Our ref: NO/2012/103537/01-L01
Your ref: 3/2012/0256
Date: 20 April 2012

**PROPOSED EARTH BANKED SLURRY LAGOON
WATT CLOSE FARM, BURNLEY ROAD, GISBURN**

PLAN VIEW OF PROPOSED LAGOON

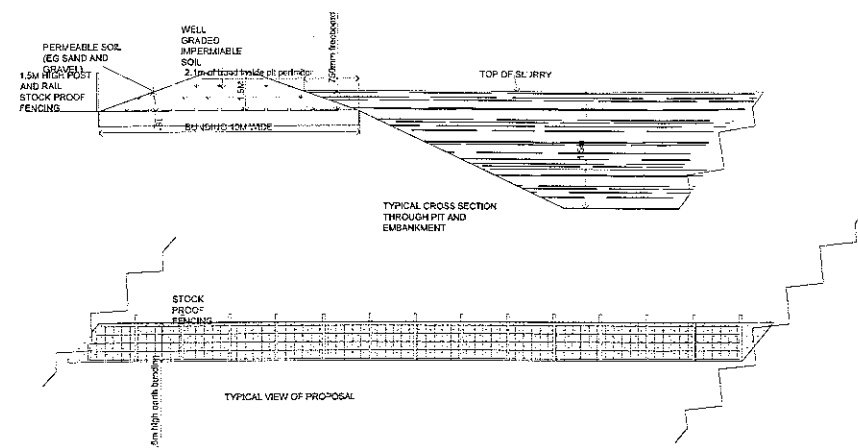
Both the slurry lagoon and silage clamp must be constructed to meet the Silage, Slurry and Agricultural Fuel Oils Regulations.

If the slurry lagoon is proposed to be constructed from in-situ clay, a permeability test should be undertaken to confirm suitability and the results sent to the Environment Agency. The regulations also require other key engineering requirements. Factsheets 3 and 5 on the link below provide further details, together with the soil suitability guidance.
